**Application Number SSI 7485****WestConnex M4-M5 Link – Modification 2 The Crescent overpass****Tony & Kathy Smithies**

This is our submission regarding the proposed modifications to the Rozelle Interchange. Please forward our comments to the appropriate person/place.

Figure 4-4 Elevation: Indicative view of The Crescent overpass

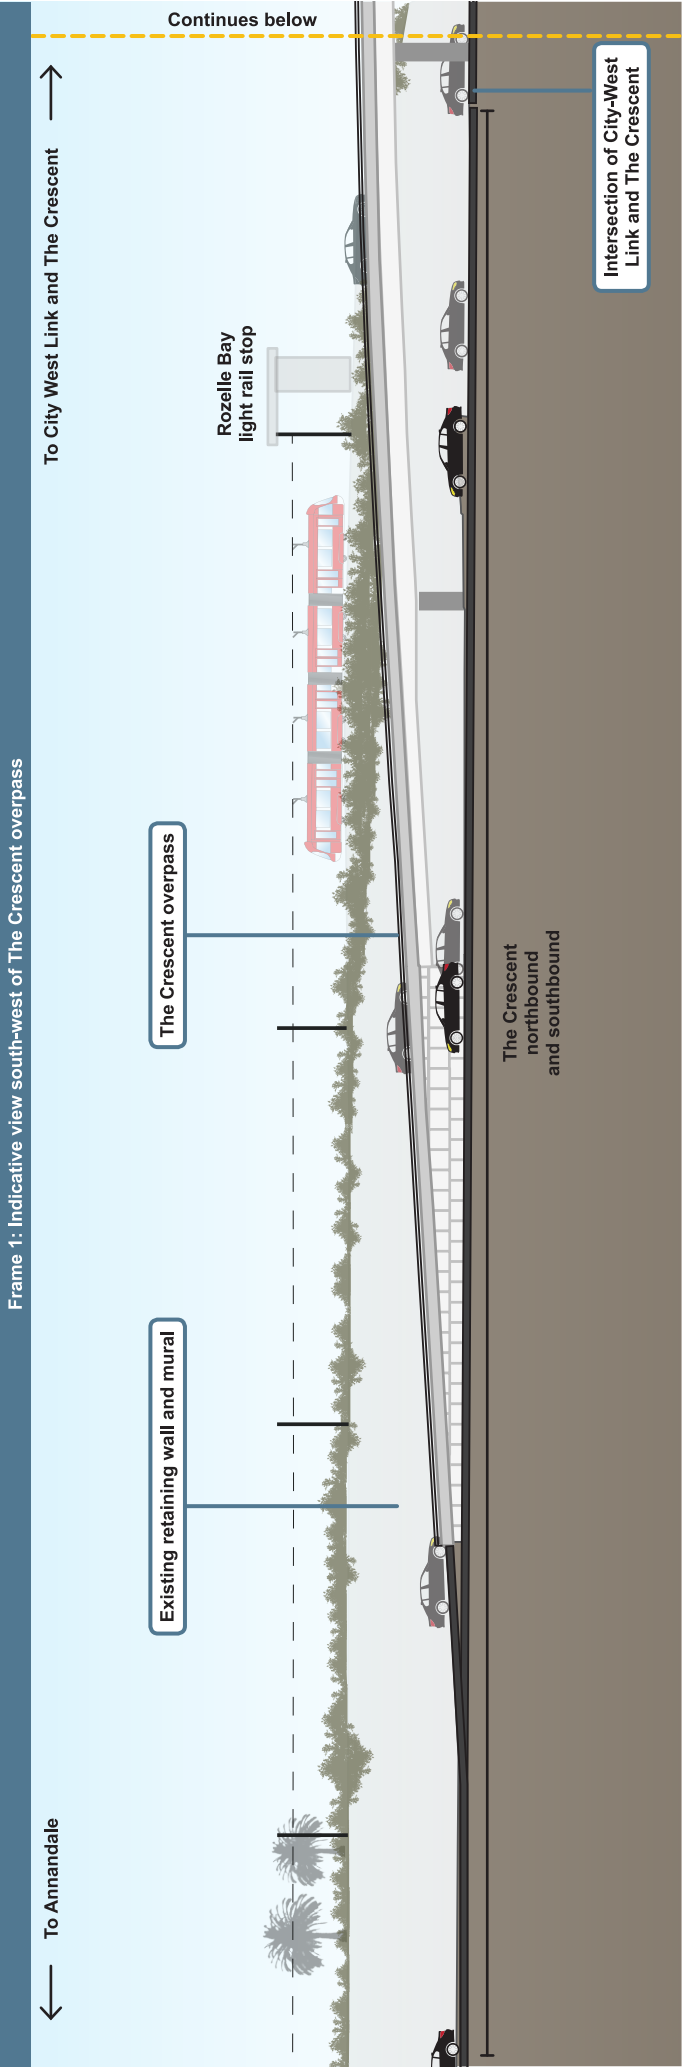
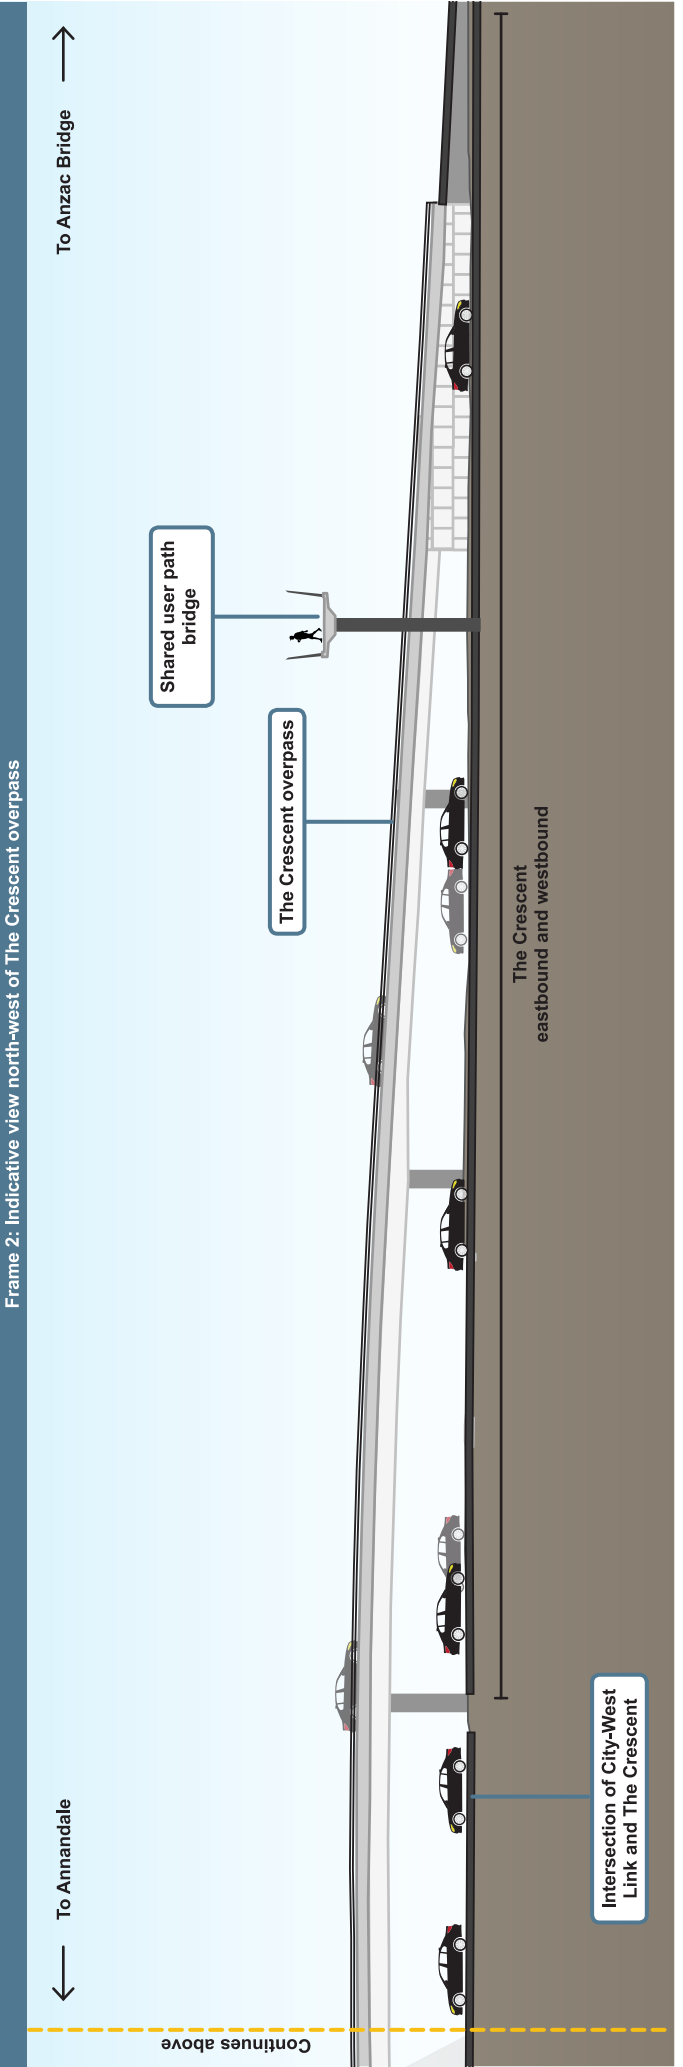
2. The proposed overpass replaces a previously planned underpass. The new proposal is visually dominating, is inconsistent with the general amenity of the area and in particular will reduce visibility of an important piece of community art on the embankment flanking the light rail line. The proposed road development will generate additional traffic pollution. The need to remove a number of significant fig and other trees from Buruwan Park will obliterate the current amenity of this heavily-used precinct, with no recompense to the residents of Annandale for this loss.

Figure 4-5 The Crescent/Johnston Street/Chapman Road intersection

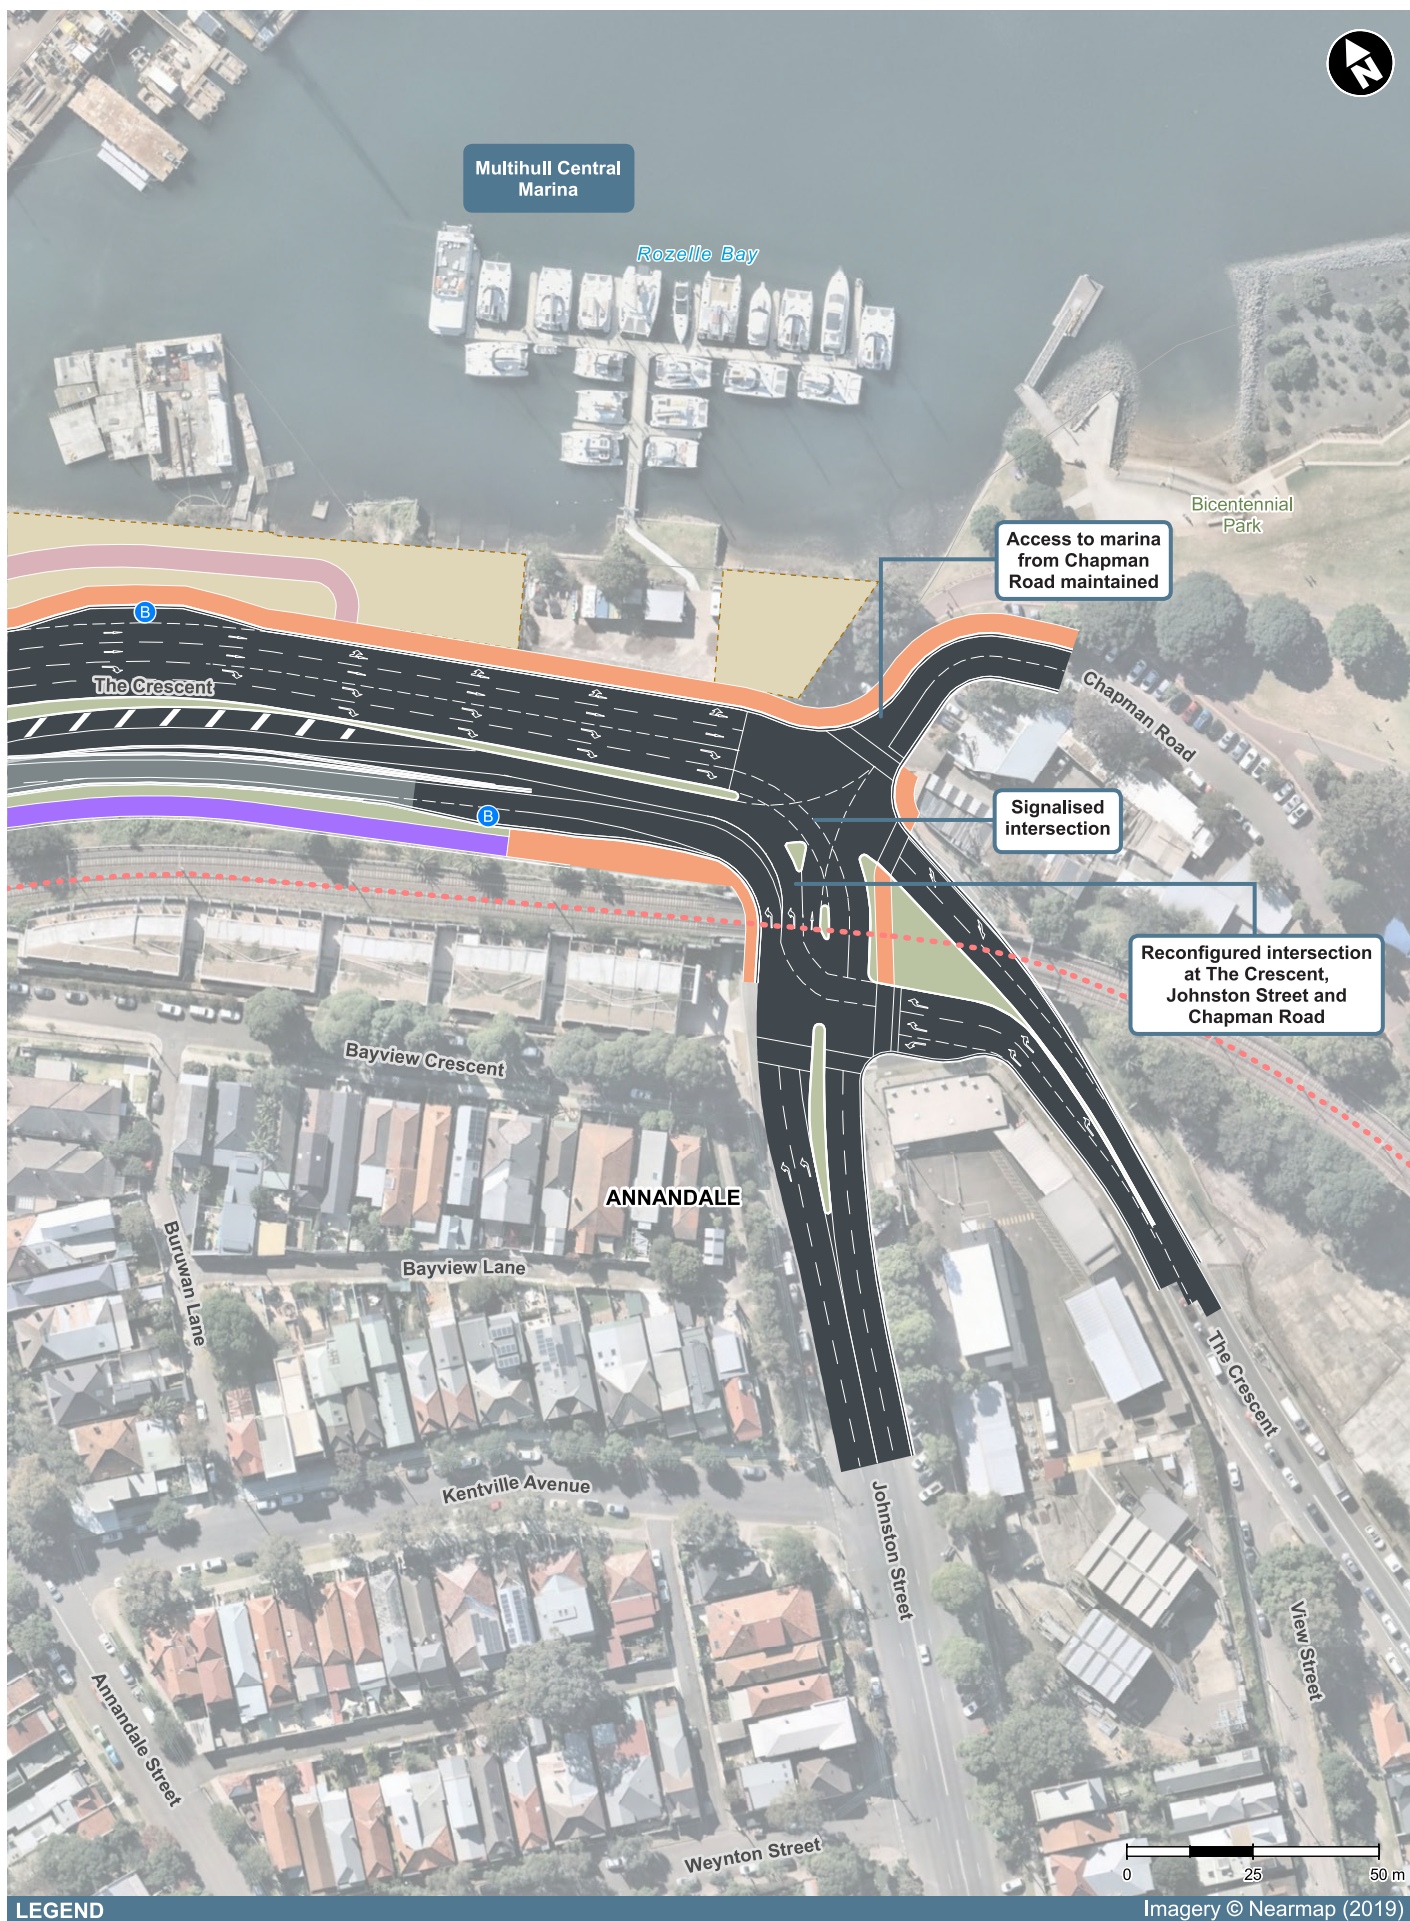
4. The revised traffic flows and traffic lights at the intersection of Johnston Street, The Crescent and Chapman Road is a real dog's breakfast (and a potential dog killer). The need for this revised traffic flow arises from the planned overpass. The pedestrian route from Johnston Street to Bicentennial Park is heavily used by pedestrians, often with dogs and/or with prams and small children. School children also use this route to/from schools in Glebe and Annandale. Cyclists also use this route heavily both for recreation and for commuting to the city. The revised plan will require all this non-vehicular traffic to navigate at least four sets of traffic lights in each direction, instead of the current one set of lights.

Figure 4-6 Elevation: Indicative view of Rozelle Rail Yards Pedestrian and Cycling Green Link

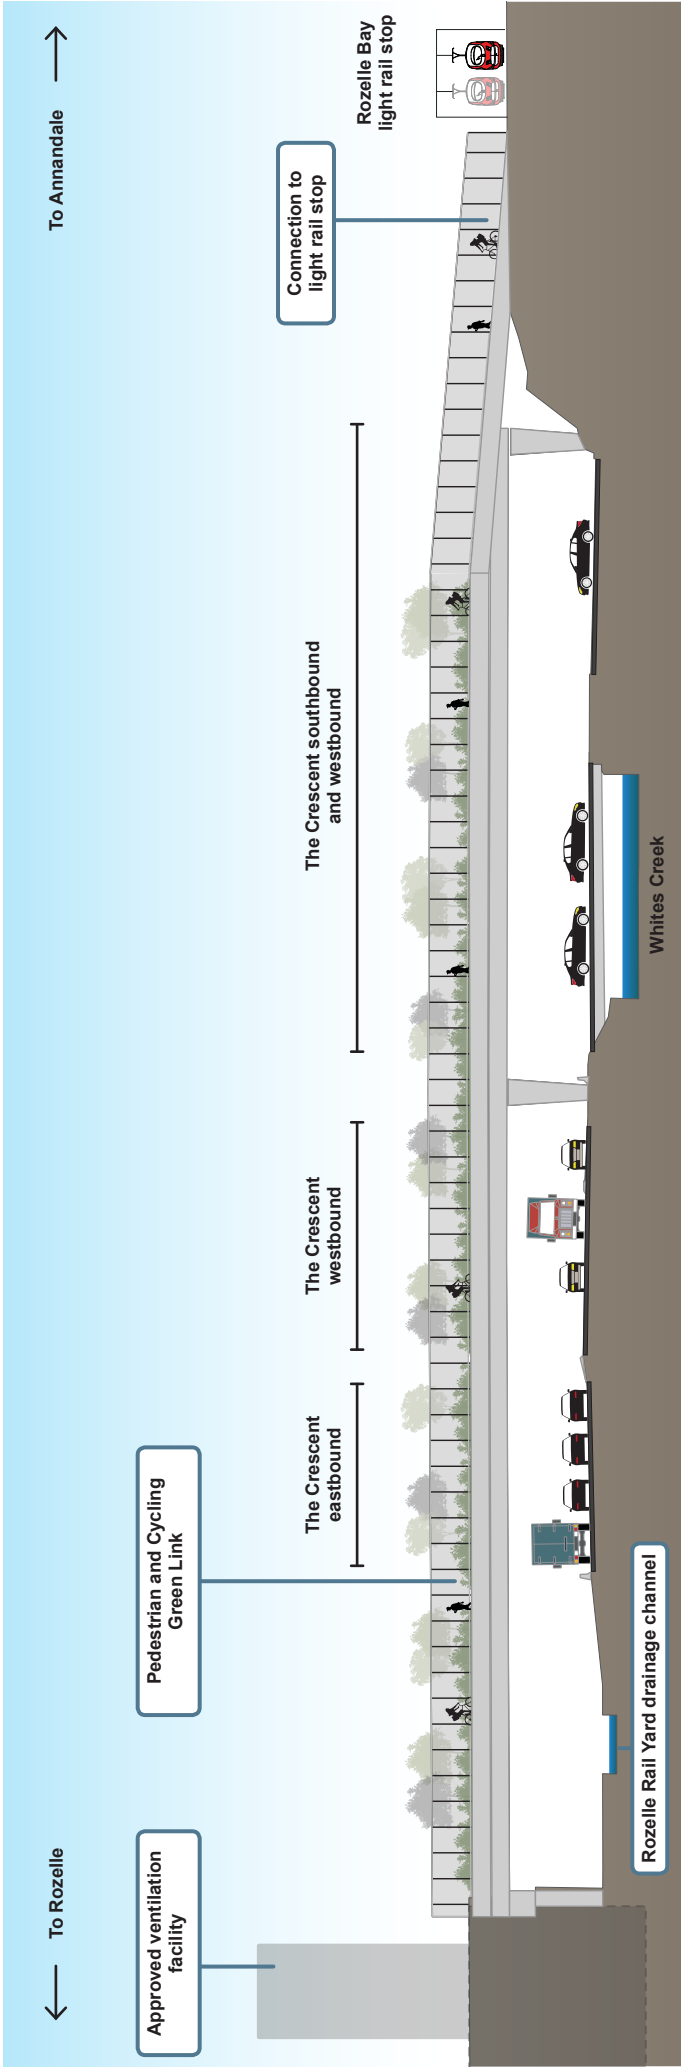
3. The 'Greenway' pedestrian/cycle access between Rozelle Bay Light Rail and the planned railyards park. It seems that this will be quite wide enough to carry separate pedestrian and cycle lanes. As pedestrians we are well aware of the threat of cyclists sharing the same lane. As cyclists we are also well aware that pedestrians often are inattentive, and many are deaf to cycle bells because of their use of headphones. The separated lanes around Iron Cove are not perfect (too narrow), but they are a great improvement on the previous single shared lane. It would be a

retrograde step to build another shared lane, especially when there seems no space restriction on the use of double lanes.
